Re: SSD 9606 - UNSW Building D14 Redevelopment

Thank you for the opportunity to comment on the Response to Submissions (RtS) Report prepared by Ethos Urban on behalf of the University of New South Wales (UNSW) for the State Significant Development Application SSD 9606 – UNSW Building D14.

Council has reviewed the Applicant's Response to Submissions Report dated 17 April 2019 and provide the following comments for the Department's consideration:

Cross section showing relationship of the proposed Building D14 north-eastern terraces and the White House.

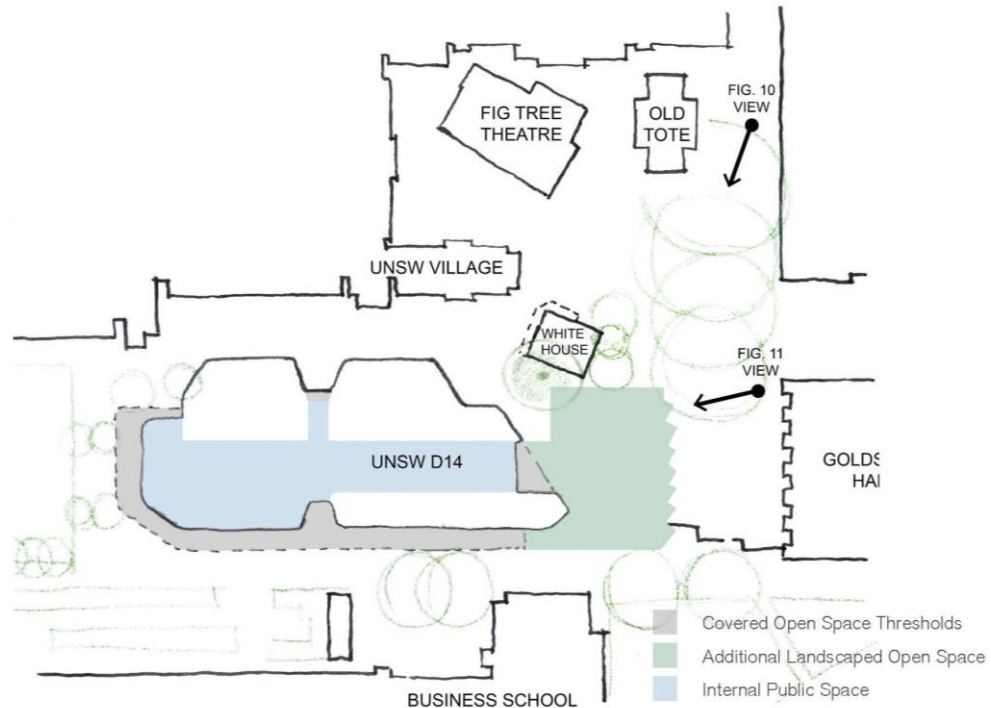
- The new courtyard area between the White House and the proposed building sits at a significantly lower level than the site of the proposed building (see page 10 of the RtS). The proposed building sits on a significantly elevated site to that of the HCA which serves to further accentuate the height, bulk and scale of the proposed building in relation to the HCA and the heritage items within. While the proponent states in the RtS that the proposal "only contains a single storey at the eastern end with a terrace above. The two storey element is in response to the sloping topography of the site and is contained within the western end, away from the Fig Tree HCA", the single storey element is located directly towards the UNSW Village buildings, significantly away from the White House HCA, so that it is a misnomer to call it a "transition" element. Like the White House HCA, the single storey element is itself significantly overwhelmed by the massive height, bulk and scale of the proposed building behind it so that its role and effectiveness as a "transition" element is doubtful.

- Whilst "understorey relationship" details have been provided in the RtS, pedestrian access and permeability between the HCA and the ground level of the new building will remain problematic. Access between the two entities can only be facilitated via passages with dedicated stairs/steps that will hamper any active hub between the two entities. Accordingly, the presentation of a square at the interface of the two elements to provide a human scale environment where the difference in levels is significant and is questionable.

Figure 16 | Trees proposed for removal by REF in red, trees proposed for removal by SSD in purple, and trees proposed for retention in green (Source: RtS)

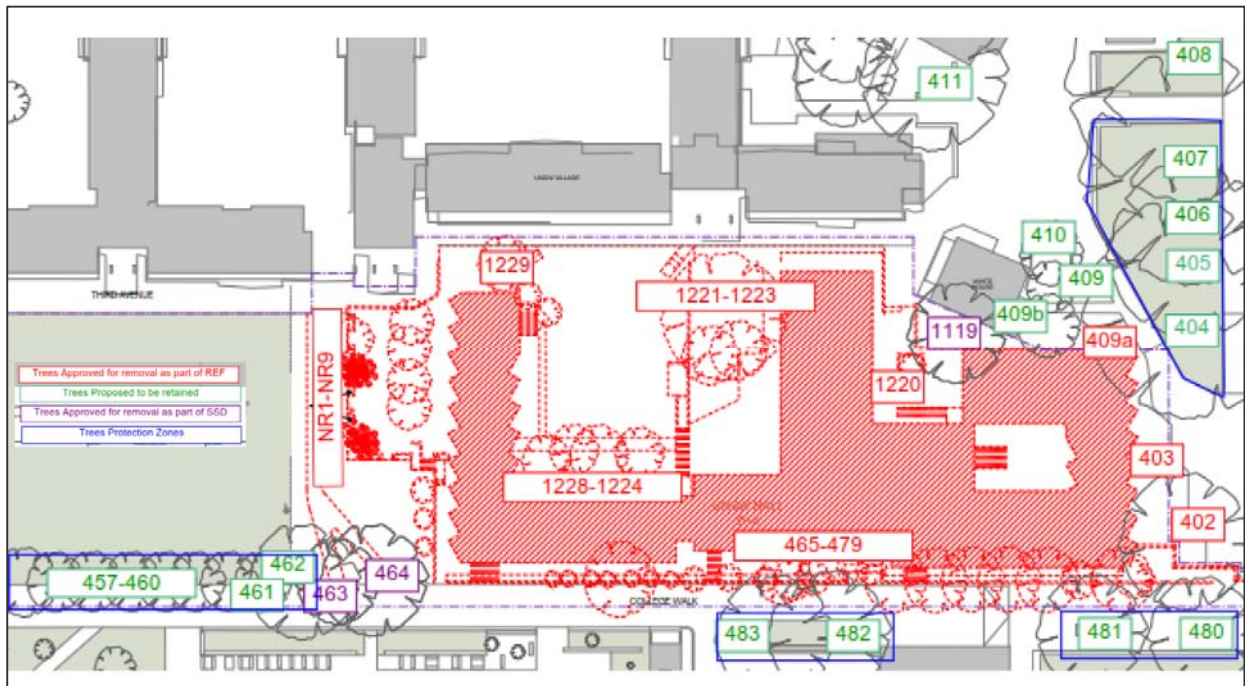
In relation to the loss of trees, Council officers again raise concern that 44 trees to be removed were already approved under a Review of Environmental Factors (REF), Part 5 of the Environmental Planning & Assessment for a 'campus upgrade' (refer page 4 of Arborists Report). This involves the majority of trees in this area while only 3 trees within the site are proposed to be removed under the SSDA proposal.

Council officers raise concern on the cumulative loss of trees in the local area and notes that there will be a shortfall of approximately 7 trees, with 38 new tree plantings proposed as part of this development.
